**KIRKLEES METROPOLITAN COUNCIL
INVESTMENT & REGENERATION SERVICE**

DELEGATED DECISION TO DETERMINE PLANNING APPLICATIONS

Reference No:	2022/62/91839/W
Site Address:	7, Gatesgarth Crescent, Lindley, Huddersfield, HD3 3LG
Description:	Erection of two storey side extension
Recommending Officer:	Tom Hunt

Officer Report

PROPOSED SOUTH WEST FACING ELEVATION
SCALE 1:100

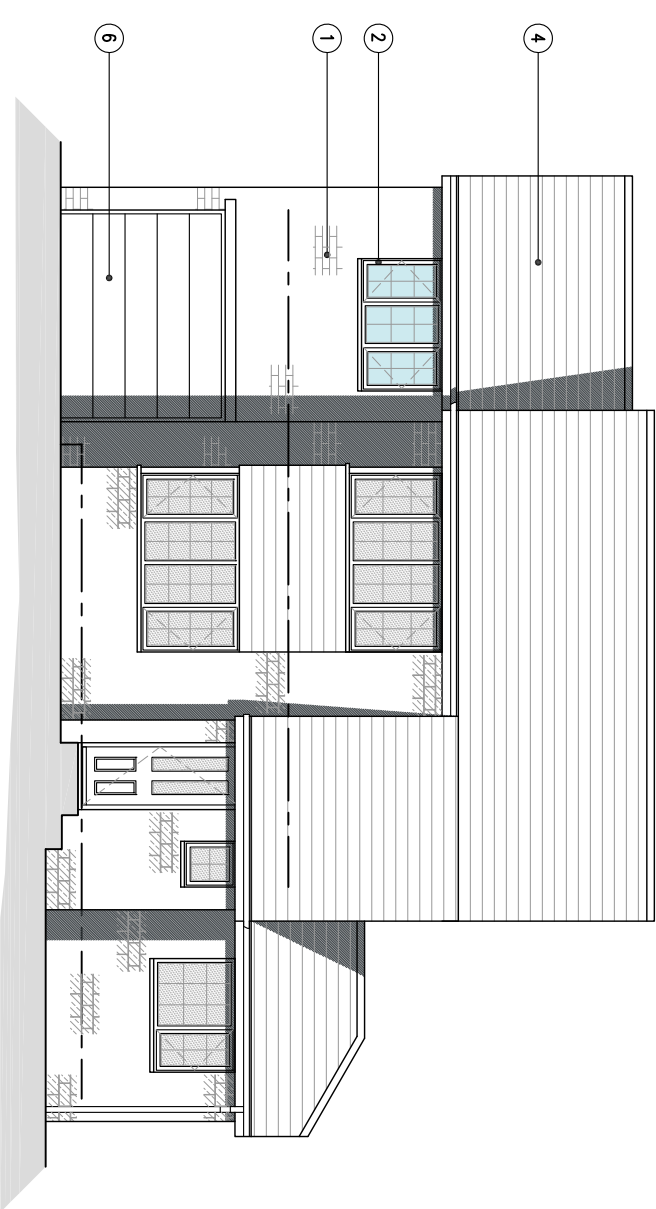
The proposed would be within a broadly wedge-shaped plot to the side of the host with there being a gap of ~0.7m-2.6m to the flank plot boundary. This would be within the established flank elevations to flank plot boundary shown within the streetscene and would not appear out of keeping whilst retaining a gap. To have a wedge shaped extension to maintain a full 1m gap would appear incongruous with the form of the dwelling and streetscene design. It is also considered that given there is no side wall adjacent to this extension, the separation from the boundary would be sufficient to prevent a terracing effect or the development appearing cramped on the site. The extension would be set back ~0.6m from the main body of the house set behind the bay window extension enabling the property to meet the design guidance set out in the SPD.

The two storey side extension would be set down from the host dwelling's roof ridge and set back from the main body of the dwellinghouse and be of modest width and projection aiding in the extension's scale appearing broadly subservient to the main dwelling. It would have low embodied energy materials and detailing to match the host with a side gable roof to the host's own side gable roof enabling the design to be a cohesive and harmonious addition.

For a 4 plus bedroom dwelling, it should have three off street parking spaces. Currently three are indicated within the application site at the end of the close on plans. Whilst the indicated cars on plans submitted are 2m by 4.6m approximately which is under the 2.4m by 5m sought by Officers, there appears to be more than sufficient space to provide off-street parking spaces for at least two cars. There are regular bus links to Huddersfield within 3 minutes walk and to the nearest centre at Lindley which is within reasonable walking distance towards Lindley albeit down a steep slope in good conditions. The undersupply of parking for three cars can reasonably be supported by the frequent public transport links to centres and access to services.

4. Prior to the hereby approved extension being first brought into use, two parking spaces measuring a minimum of 2.4 metres wide by 4.8 metres long shall be provided within the site outlined in red on the hereby approved 'Proposed Floor Plans, Elevations and Site Plan. Drawing No. 117-22-PL02. Revision: C.' The spaces shall be laid out with a hardened and drained surface in accordance with the Communities and Local Government; and Environment Agencies 'Guidance on the permeable surfacing of front gardens (parking areas)' published 13th May 2009 (ISBN 9781409804864) as amended or any successor guidance. Notwithstanding the provisions of the Town and Country Planning (General Permitted Development) Order 2015 as amended (or any Order revoking or re-enacting that Order) these areas shall be so retained, free of obstructions and available for the parking of vehicles.
